**WELWYN HATFIELD BOROUGH COUNCIL
EXECUTIVE DIRECTOR - PLANNING, PUBLIC PROTECTION AND GOVERNANCE**

DELEGATED APPLICATION

Application No: 6/2017/0452/EM
Location: 22 Stanborough Road Welwyn Garden City AL8 6XD
Proposal: Erection of first floor side extension and insertion of port hole window to existing front elevation
Officer: Mrs S Smith

Recommendation: Refused

Drawing No: 4046-P01 Revision:

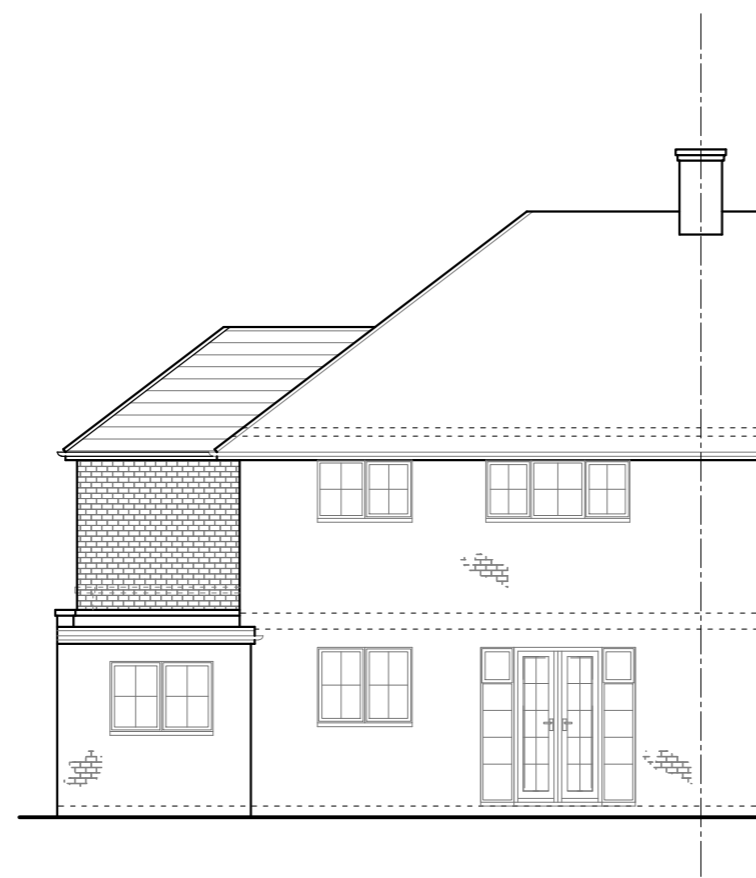
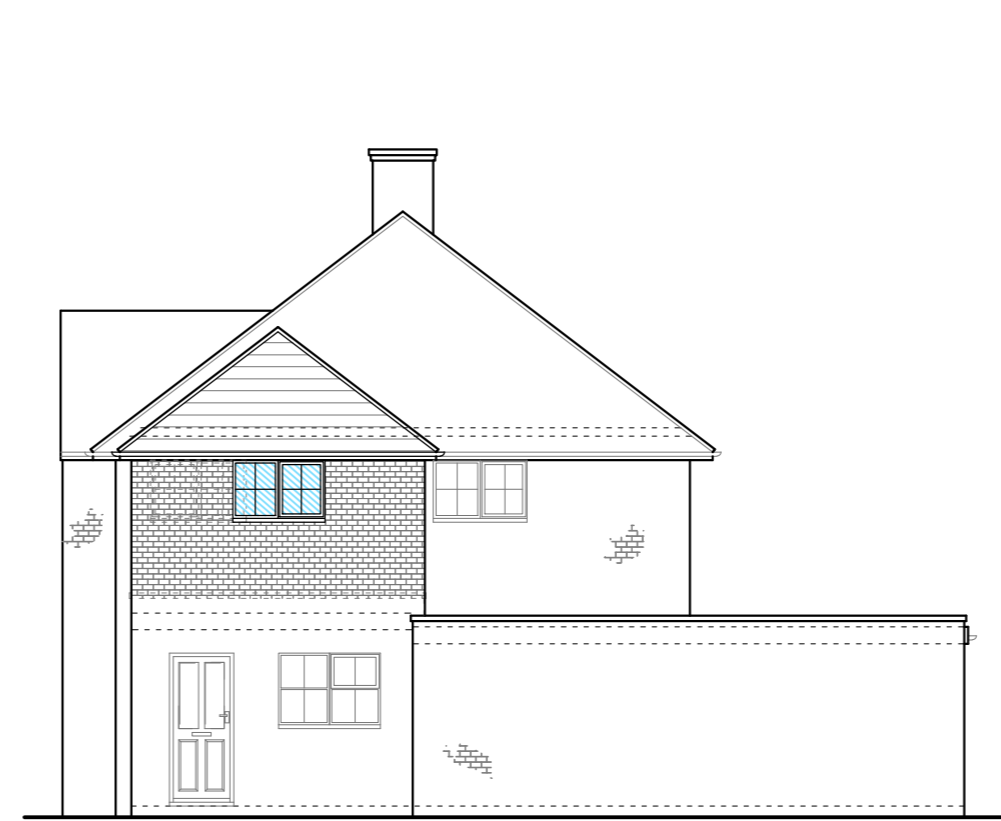
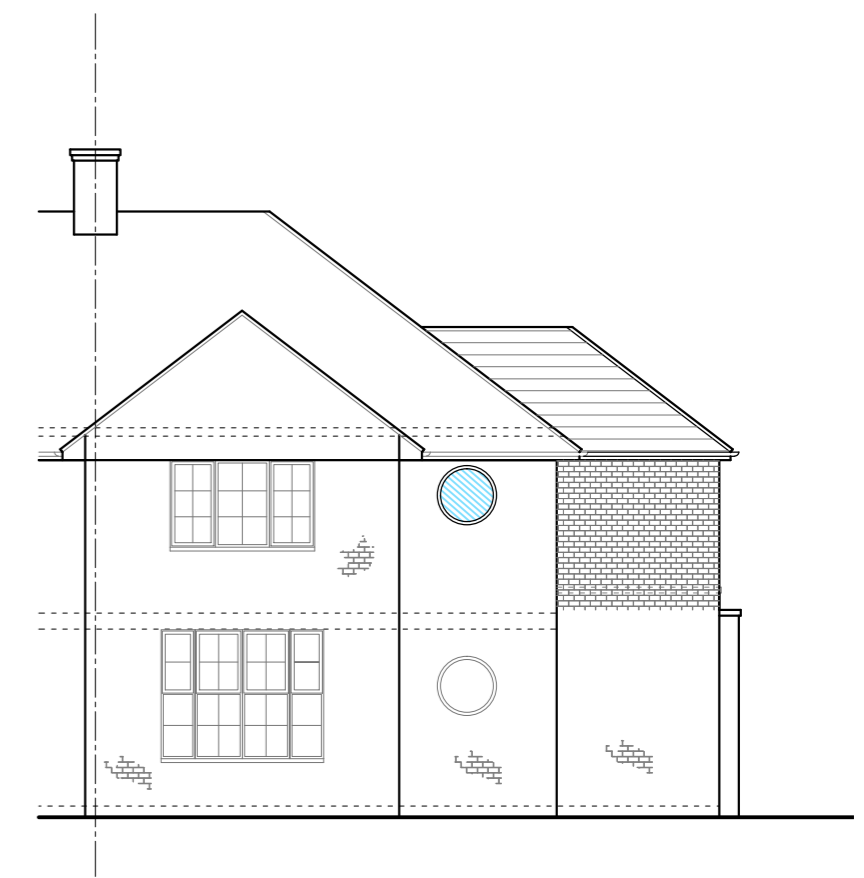
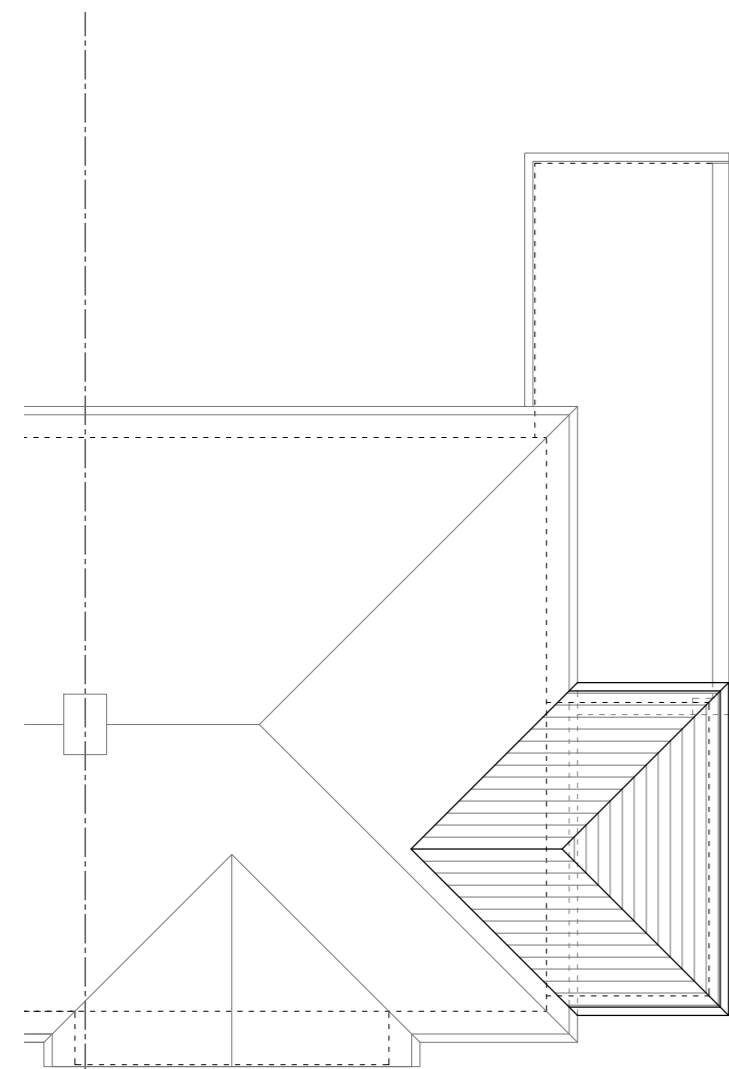
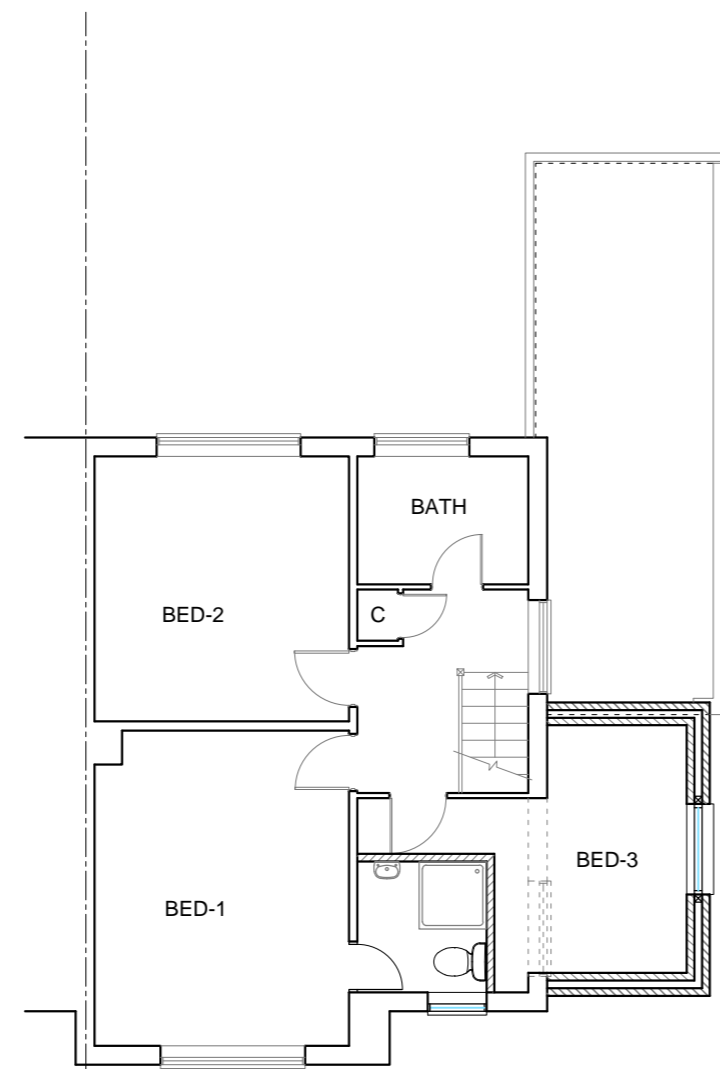
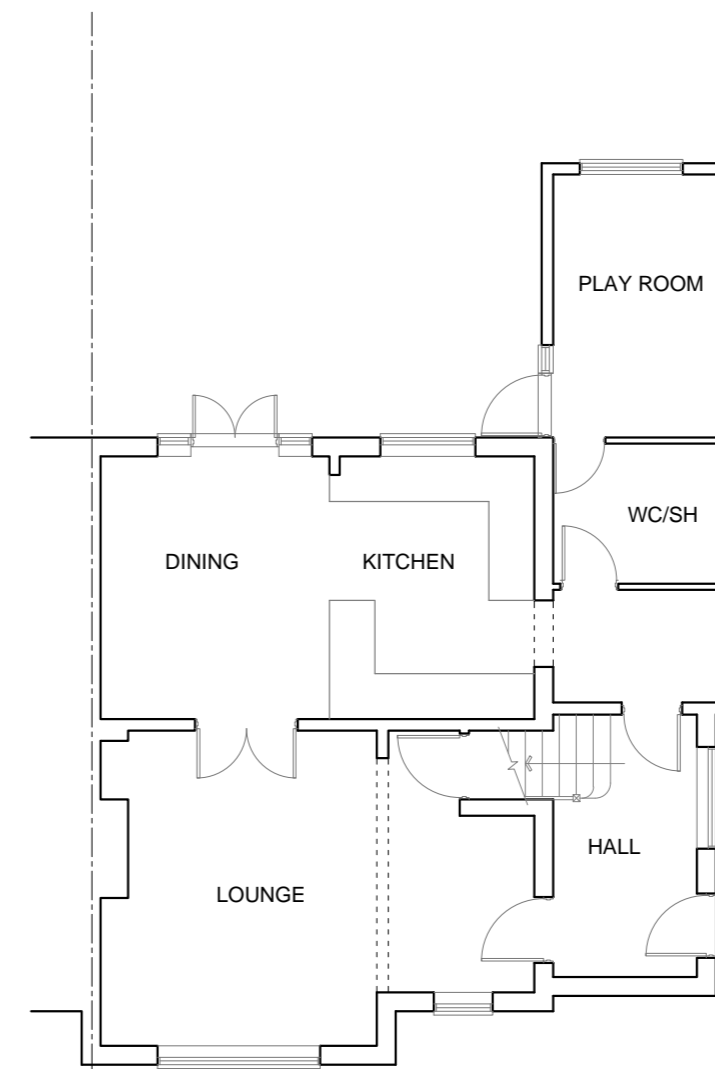
(impact upon amenities and values of Garden City)	<p>extension would be set down from the ridge of the roof of the property. As a result it would be considered to be subordinate to the overall size and scale of the original dwelling. However, it is to the side of the property where it has not been set back from the front elevation. As a result it would be viewed as a continuation of the existing terrace row appearing as an 'add' on and incongruous addition, disrupting the appearance of the application property and the view of the terrace from the front. This would be emphasised by its set down from the ridge of the roof of the property failing to appear as a continuation to the row of terrace dwellings. Additionally, its detailed design would be a blank wall with no fenestration which would not provide any benefits to this scheme.</p> <p>The space to the side of the property that would be maintained would be acceptable. However this does not overcome the harm identified above.</p> <p>The proposed window to the front elevation of the main dwelling would reflect the design of the existing ground floor porthole window and no objections are raised with this element of the proposal.</p> <p>Accordingly the proposed development is poor design that would not respect or relate to the character and appearance of the area. As a result it would fail to maintain and enhance the values and amenities of the Garden City contrary to EM1.</p>

1. By virtue of the location, design and appearance of the proposed extension it would appear as an incongruous addition to the application property and to the row of terrace dwellings. The proposal therefore represents poor quality design which would fail to maintain the values and amenities of the Garden City contrary to Policy EM1 of the Estate Management Scheme.
